DEVELOPMENT REVIEW BOARD
SUPPLEMENTAL SUBMITTAL

PROJECT NO. 2022-006547

Application No. SI-2022-00216

RE: Panda Express – S8-22-D8582
10126 Coors Blvd. NW
Albuquerque, NM 87114
RE: DRB Planning Review – 1st Resubmittal
DRB Project Number: 2022-006547
App. Number: SI-2022-00216

2 HAND RAILS NTS

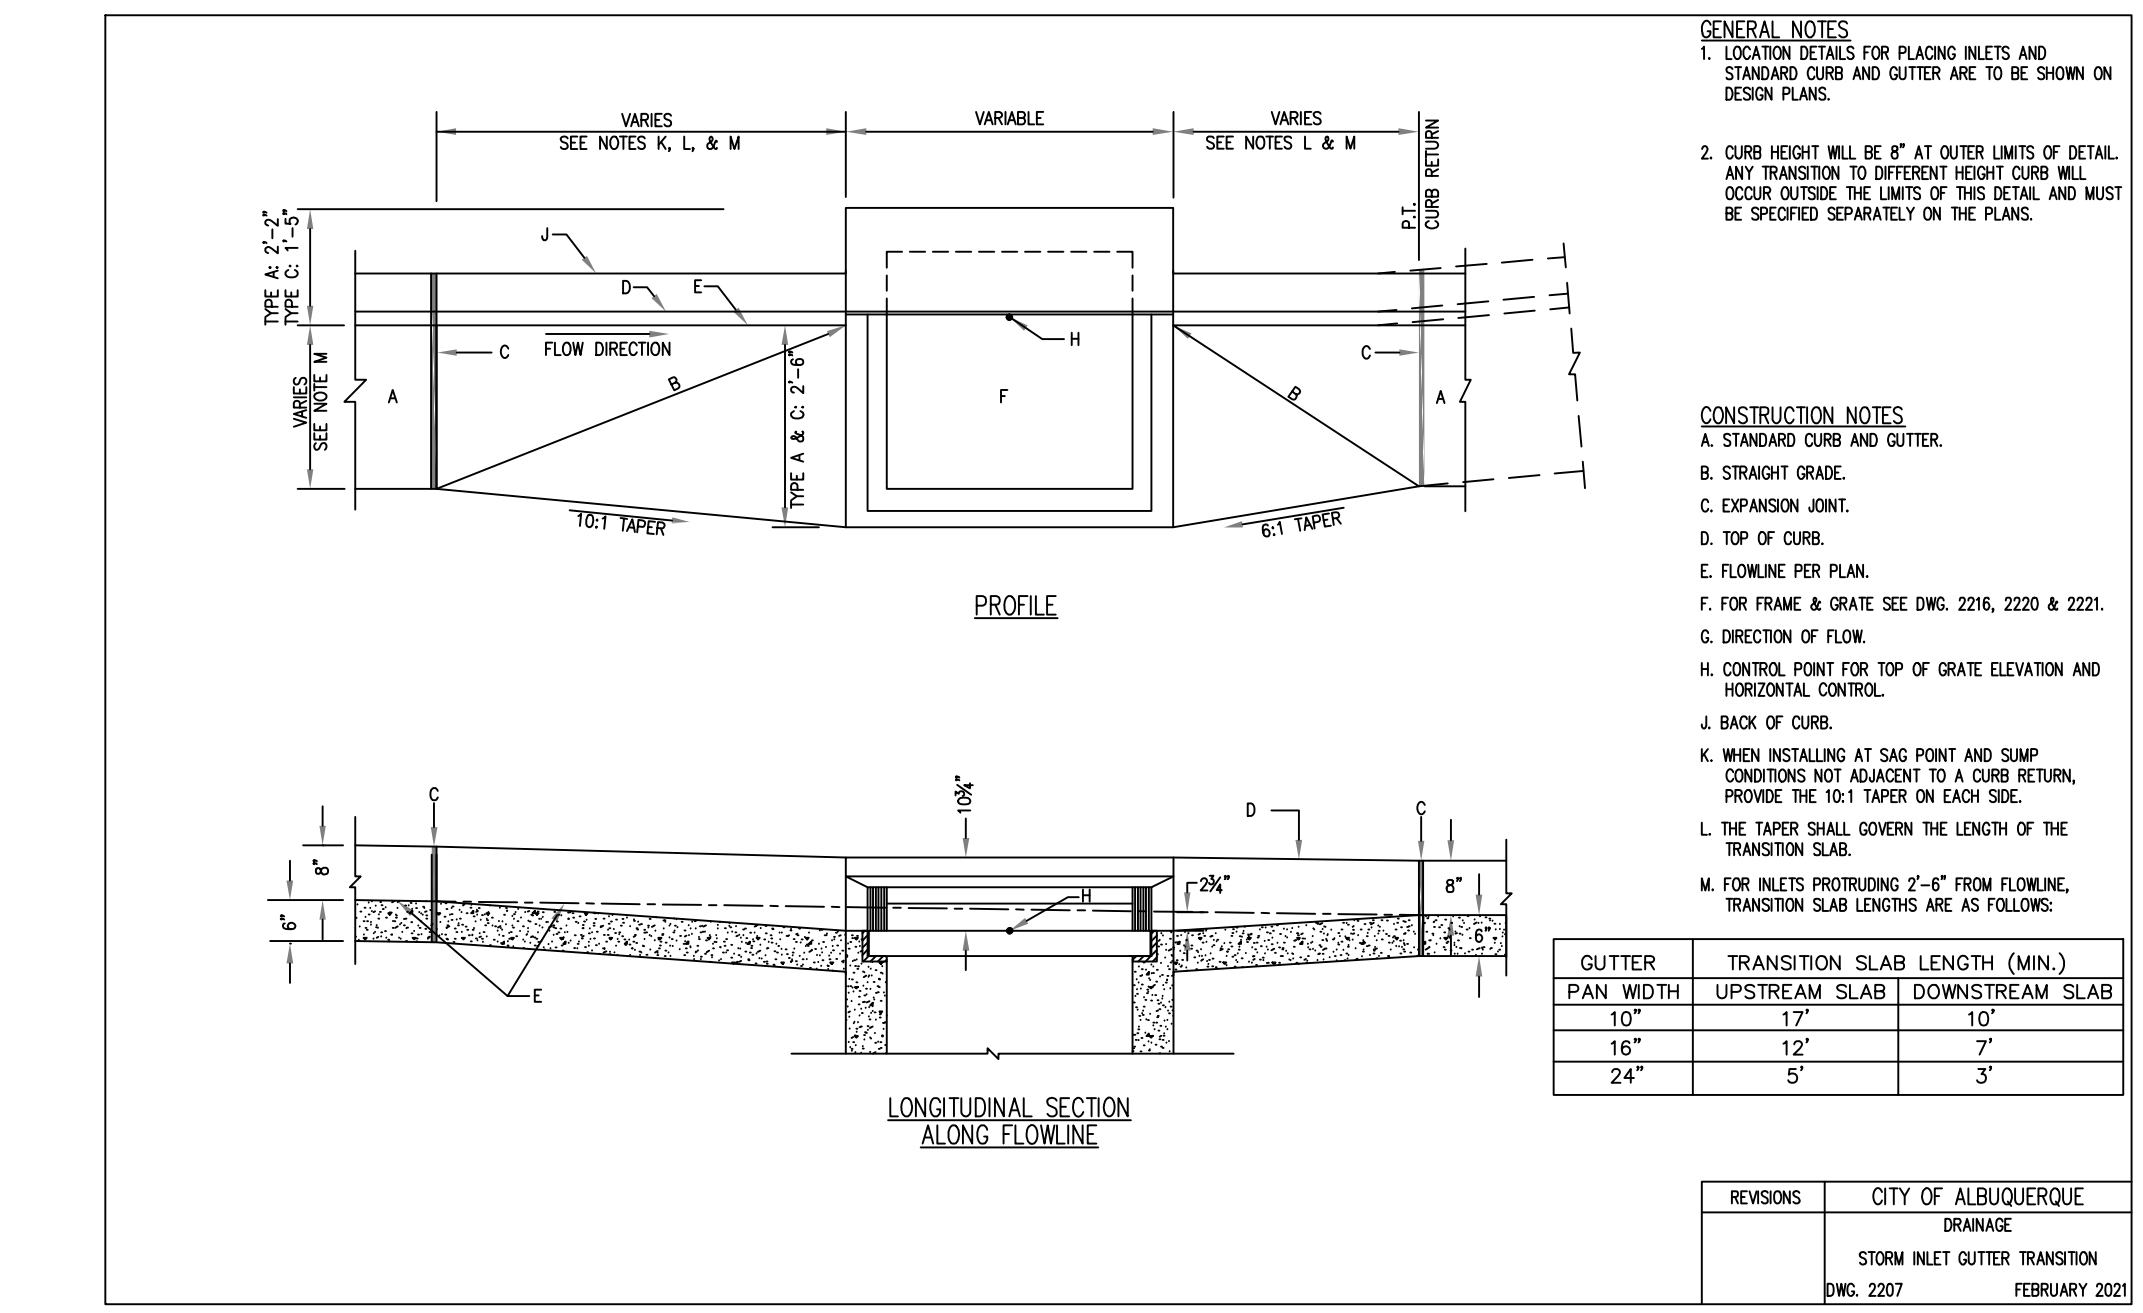
11. Motorcycle and bicycle parking details are needed. Provide these required spaces on the plan. Follow DPM requirements for the bike rack details.

Response: Bicycle parking per Figure 7.4.115 of DPM, specs per architectural plan. Motorcycle parking detail per Figure 7.4.116 of DPM

NORTH-EAST ELEVATION 4
 Scale= 3/16" - 1/0" A-202

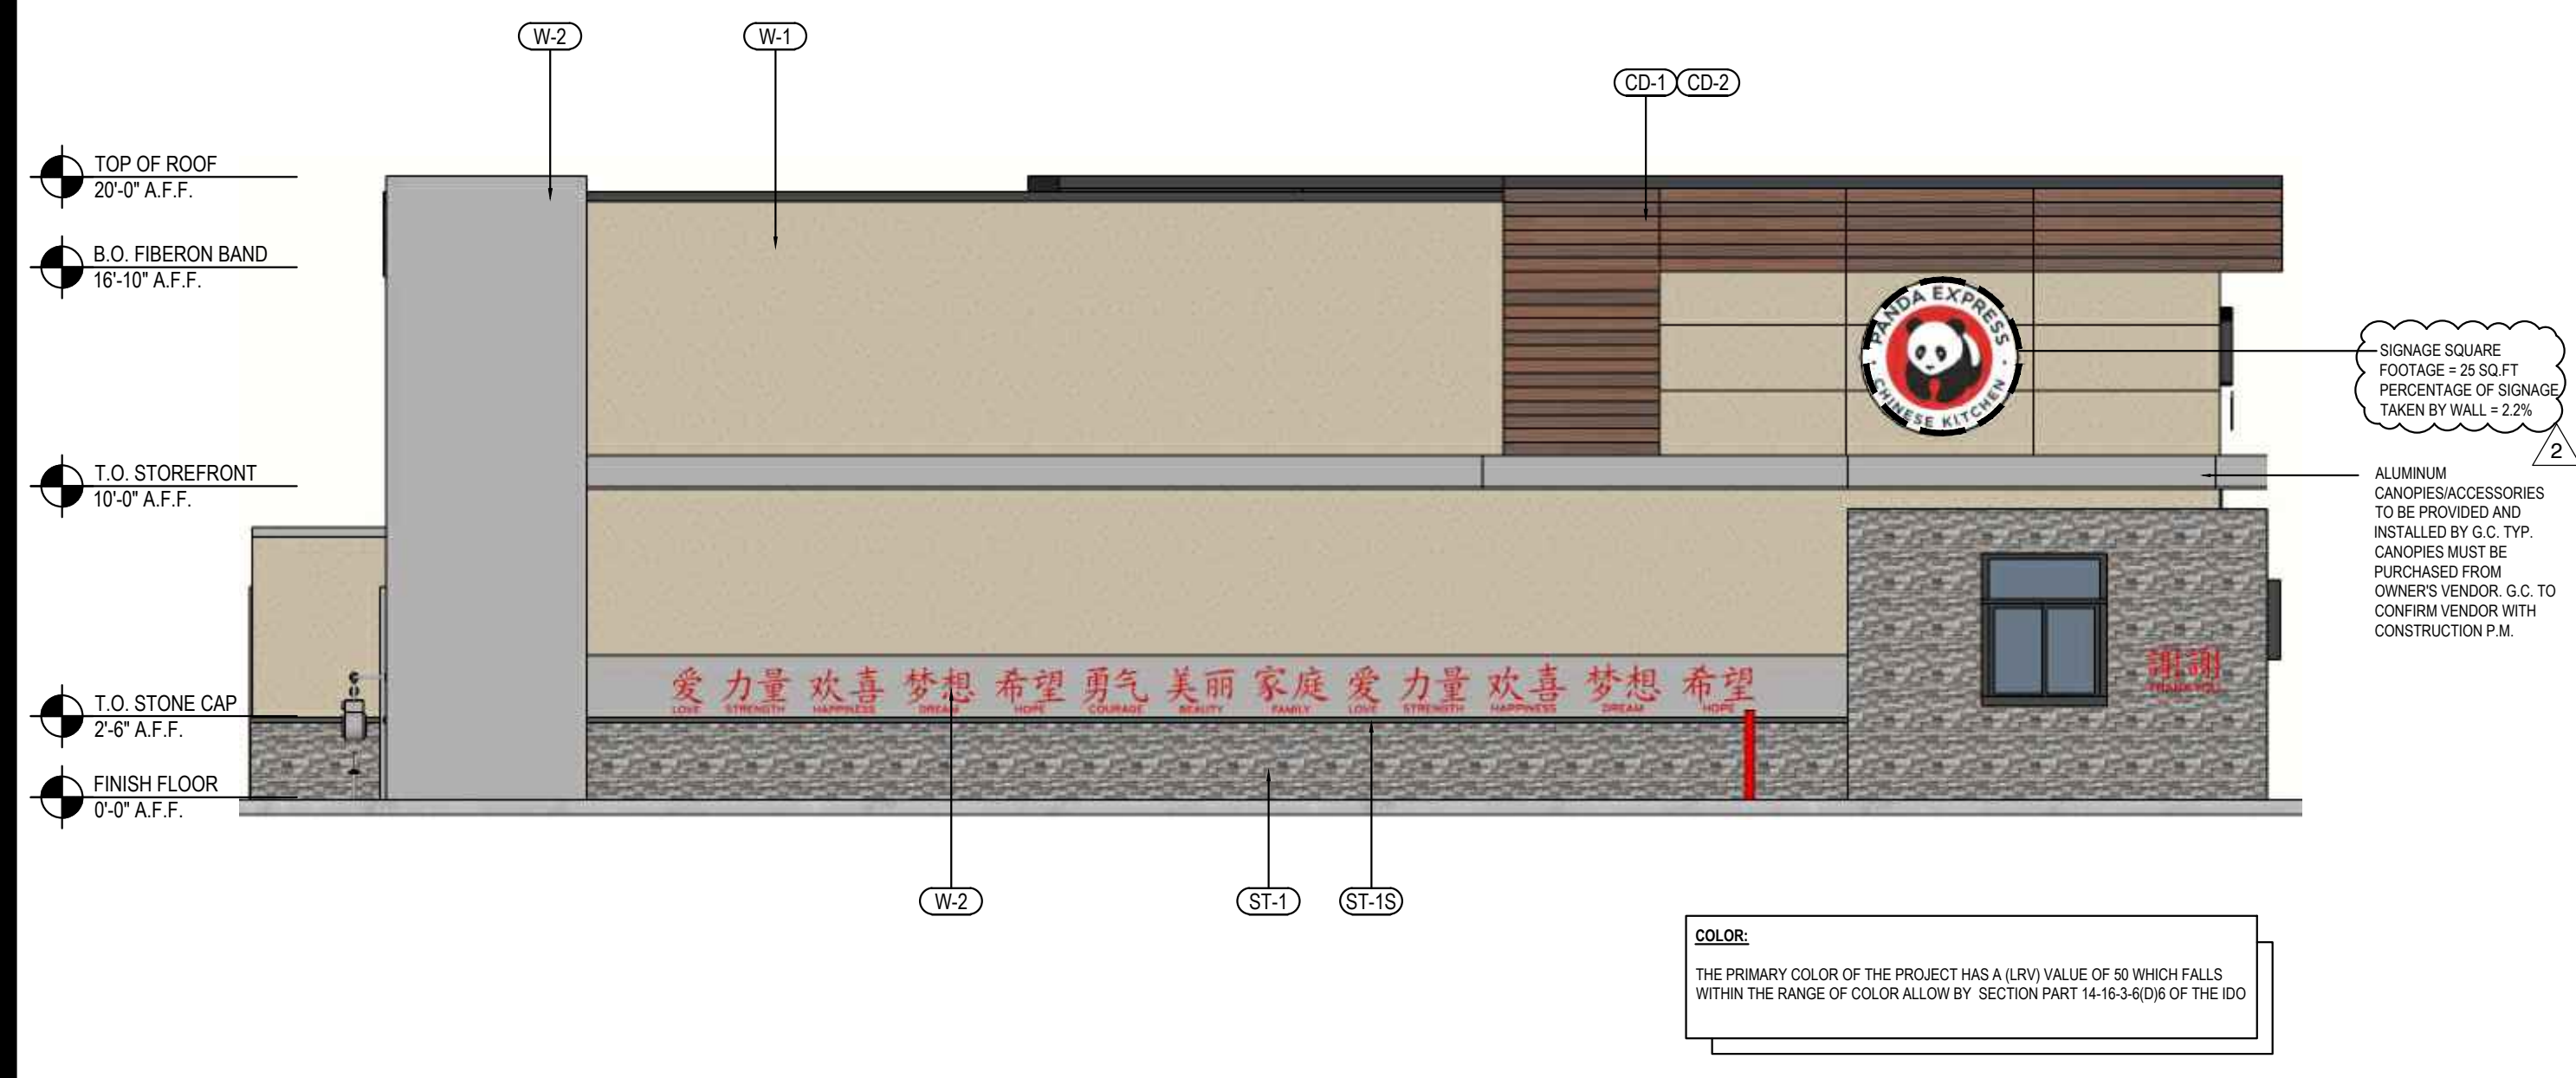
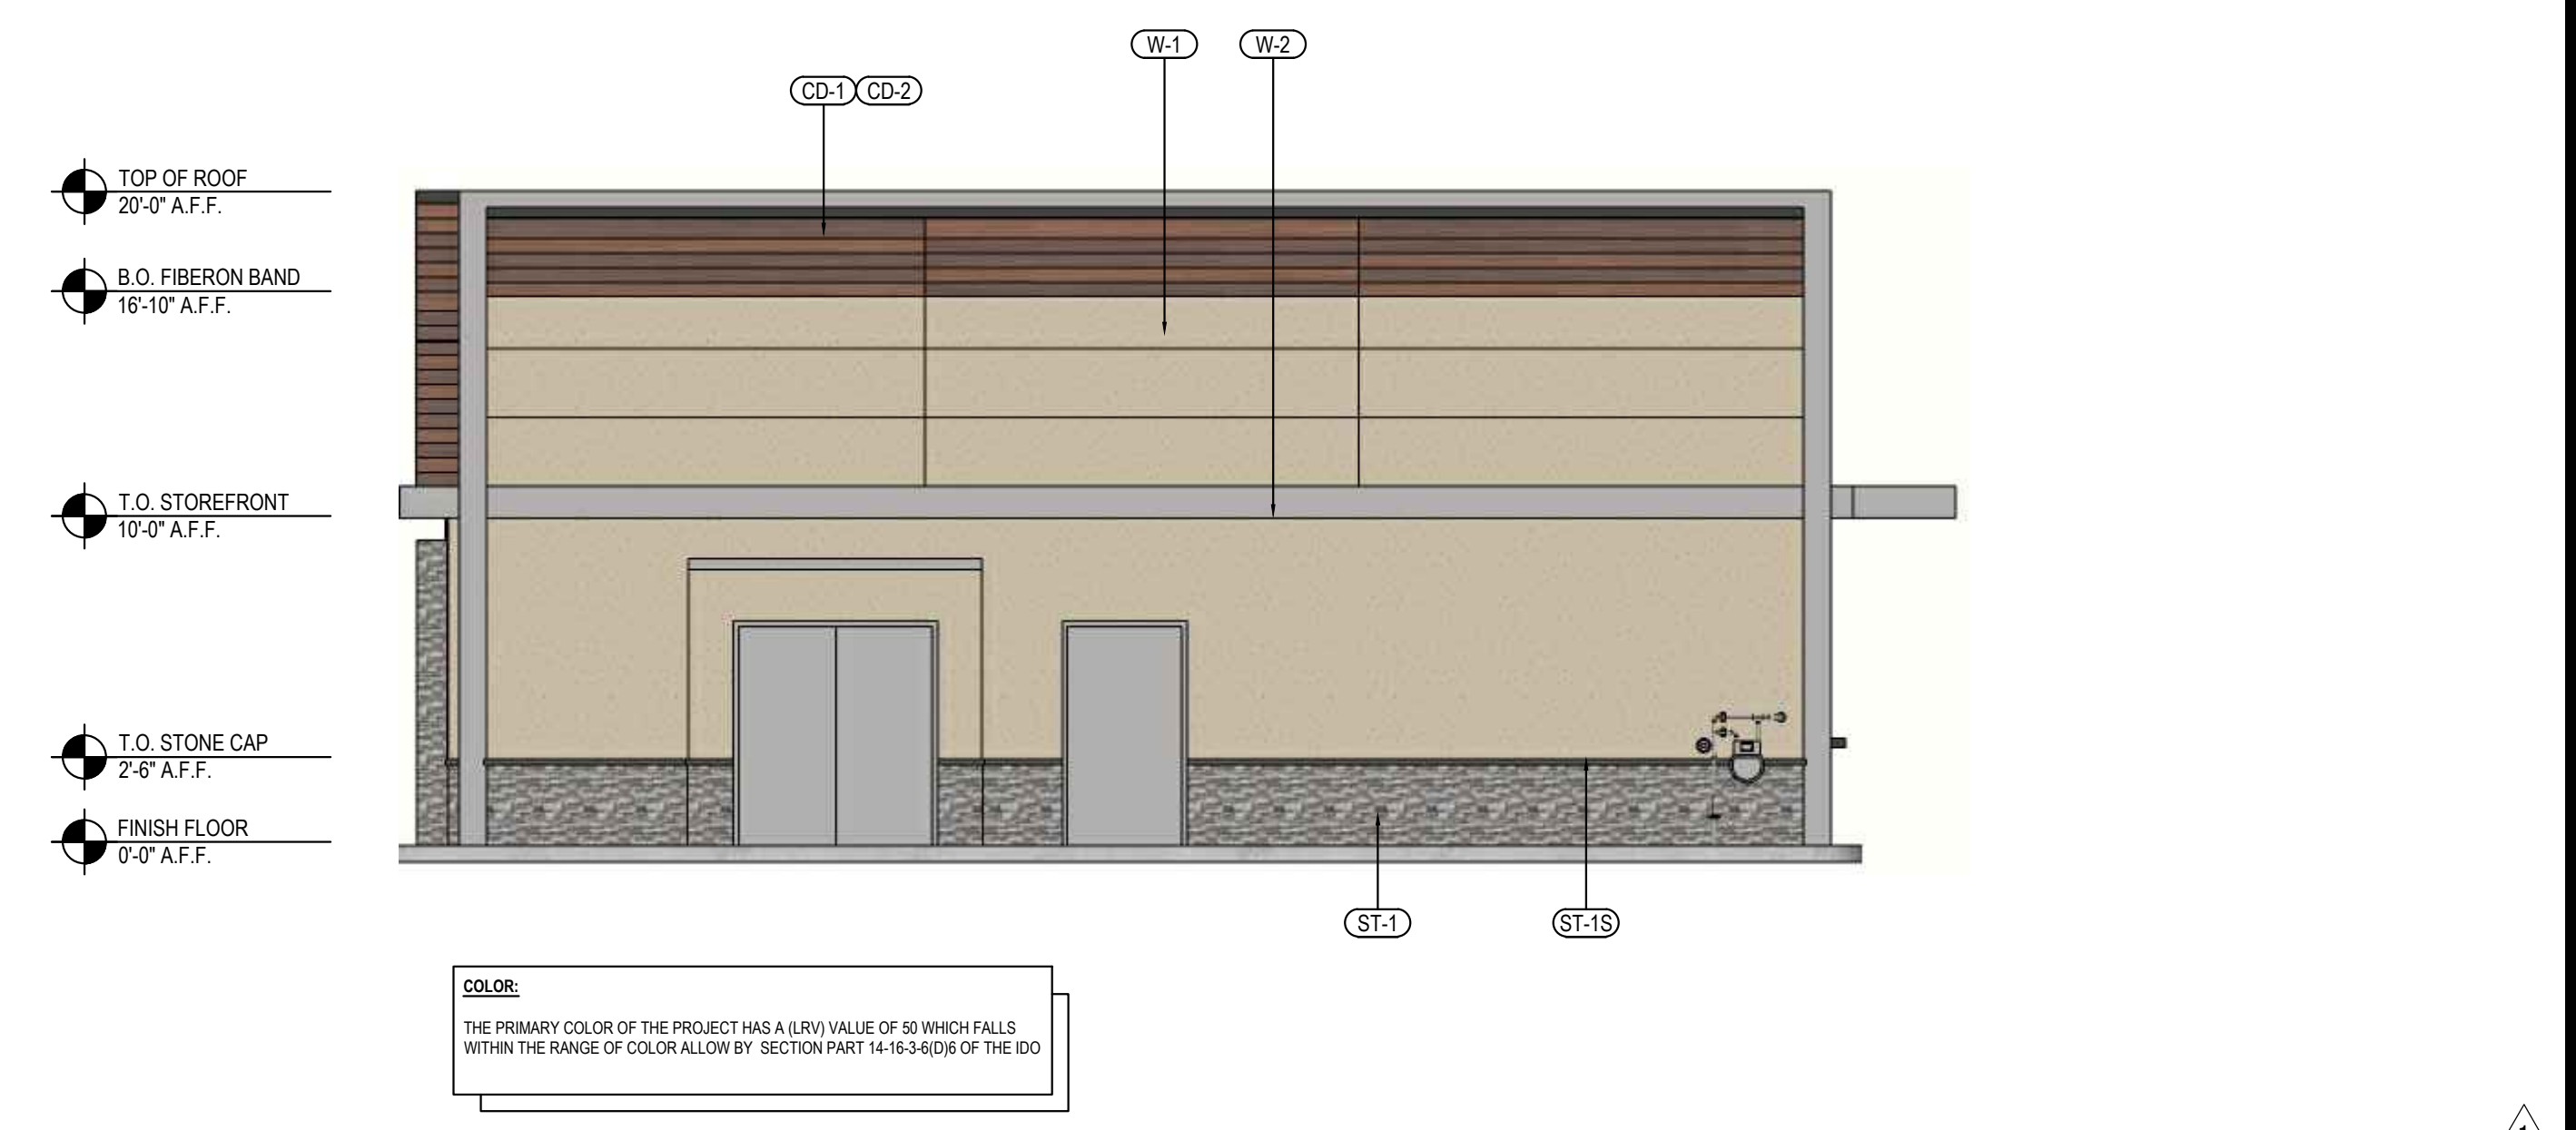
- The Building Design requirements of 5-11(E) of the IDO must be met, with confirmation provided on the elevation sheets and/or in a comment response letter.

- The % of the façade taken up by the wall signage must be included.

9. Colors of materials for façade/structures must meet all requirements of IDO 5-7, and a separate permit obtained prior to construction.

Response: Refer to sheet A-202 exterior elevations for the Building Design requirements.

Response: Refer to sheet A-202 for the percentage of the façade taken by the wall signage. The percentages are as follow Northwest is 3.4%, on the Northeast is 2.5% and on the Southwest is 2.5%

Response: Refer to sheet A-202 Exterior Elevations exterior finish schedule.
